Our ref: 25_31414_P

Your ref: H23-0313-25**Site Location:** Land At Peartree Hill Road
Whaplode Drove Spalding PE12 0SL**Summary of Proposal:** Provision of new
poultry unit & associated works

The Board has been made aware of the above application and wishes to make the following comments.

Figure 3 – Modelled Arrangement

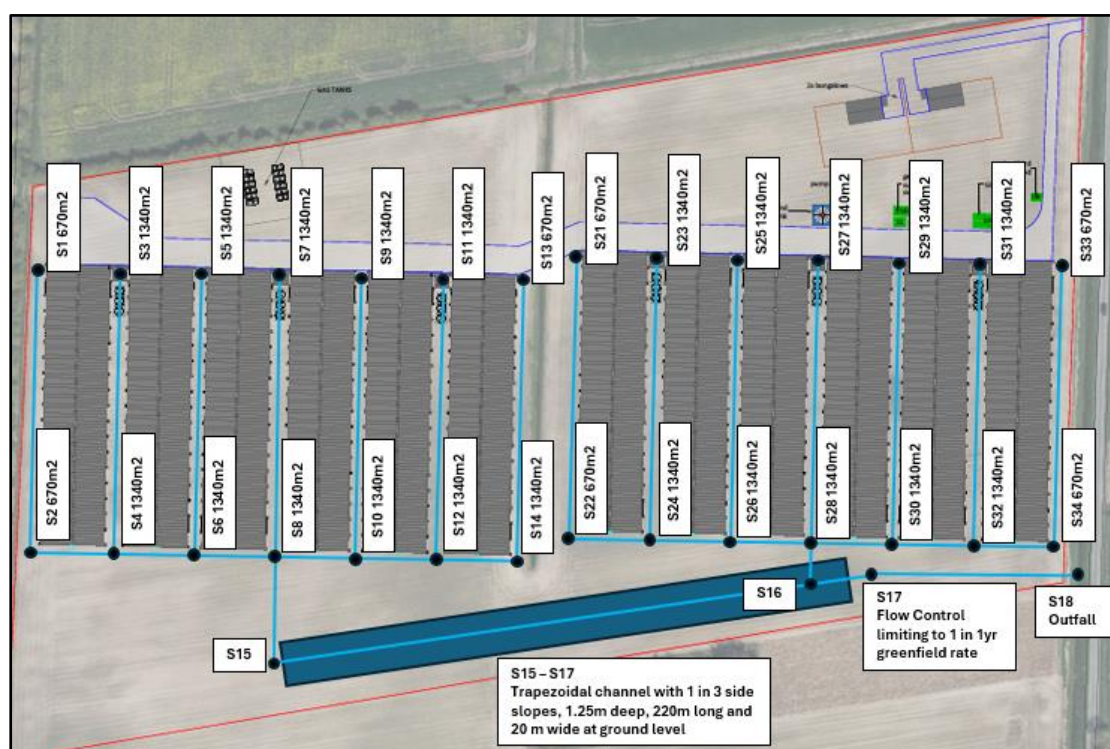
The applicant proposes to discharge surface water to a watercourse at a rate of 11.2 l/s. Whilst I understand that this is the greenfield rate for the entire site area of 9.2 ha, I note that the contributing impermeable area is less than 9.2ha and therefore, the proposed discharge rate is in excess of greenfield rate for the impermeable area only. I recommend that the applicant takes measures to reduce the rate to as near to the greenfield rate as possible for the impermeable area.

Regardless of the proposed discharge rate, this proposal will require consent under Byelaw 3, and I recommend that the applicant look into the possibility of reducing the proposed discharge rate prior to applying for consent. Please note that we recommend that any discharge is in line with the [Non-Statutory technical standards for sustainable drainage systems \(SuDS\)](#), therefore the Board is unlikely to grant consent for discharges in excess of greenfield rate. A surface water development contribution is likely to be payable as a condition of any consent granted under Byelaw 3 in line with the WMA's [Development Control Charges and Fees](#).

I note that the applicant intends to install 2no. discharge outfall pipes into the bank of the Board's owned and maintained watercourse. To enable this proposal, consent would be required under Byelaw 10, and I recommend that the applicant contacts this office to make an application for this consent at their earliest convenience. To avoid conflict between the planning process and the Board's regulatory regime, we recommend that the required consent is sought prior to the determination of this planning application.
